### **Final Report - Corrections Required** **Application No. ANEX-24-0003**

**Description : Matrix Design Group on behalf of Colorado Springs Equities LLC is submitting a serial annexation petition for seven parcels and Land Use Plan/Rezoning exhibit for a portion of the subdivision known as Rock Creek Mesa.**

**Document Filename : Project Statement\_Rock Creek Mesa\_REV2.pdf**

**PROJECT STATEMENT**  
**ROCK CREEK MESA**  
**Annexation, Rezoning, & Land Use Plan**

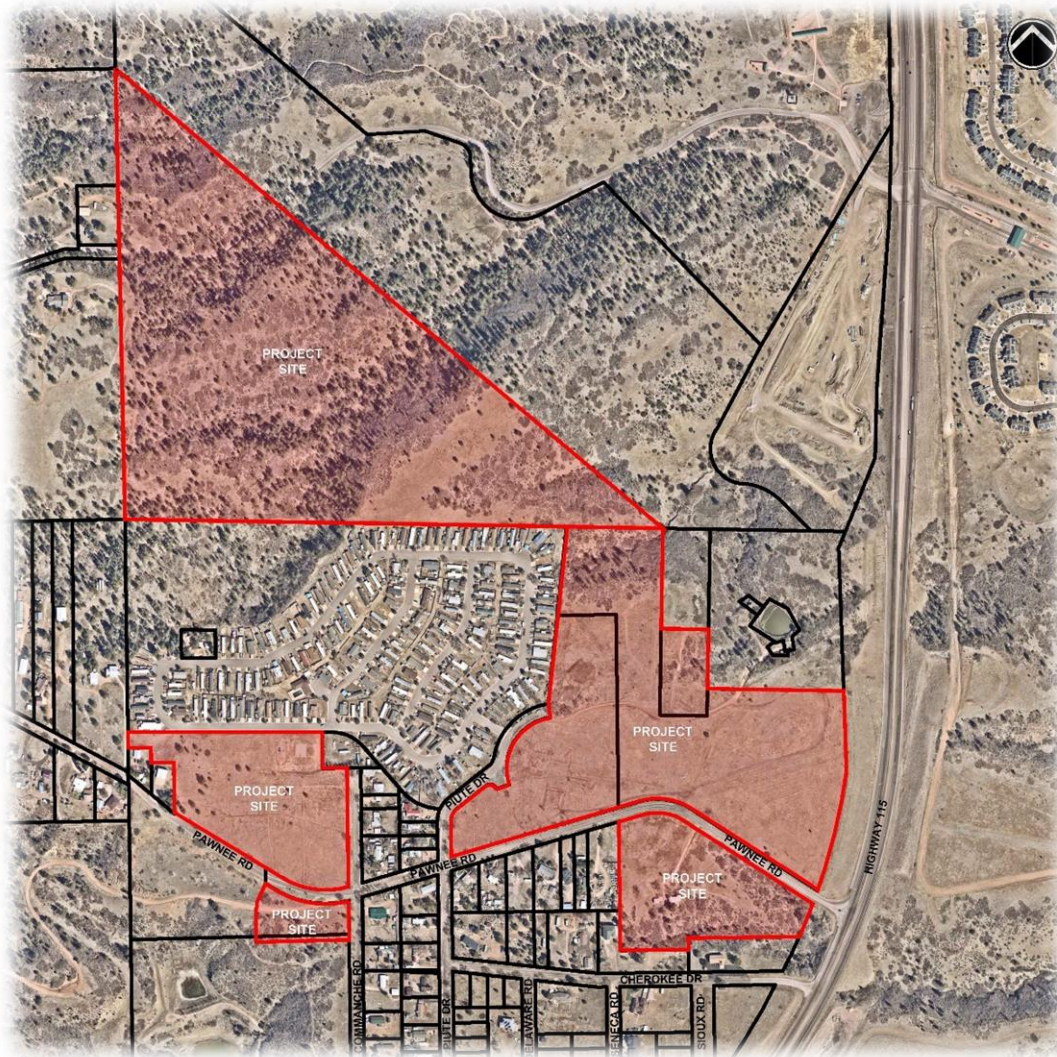
<b>Comment ID</b>	<b>Page Reference</b>	<b>Reviewer : Department</b>	<b>Review Comments</b>
34	1	Gabe Sevigny : Planning	To provide additional clarity that this property is to continue to be owned and maintain by the City, please identify this triangle as a portion of City Owned Parks and not Project site
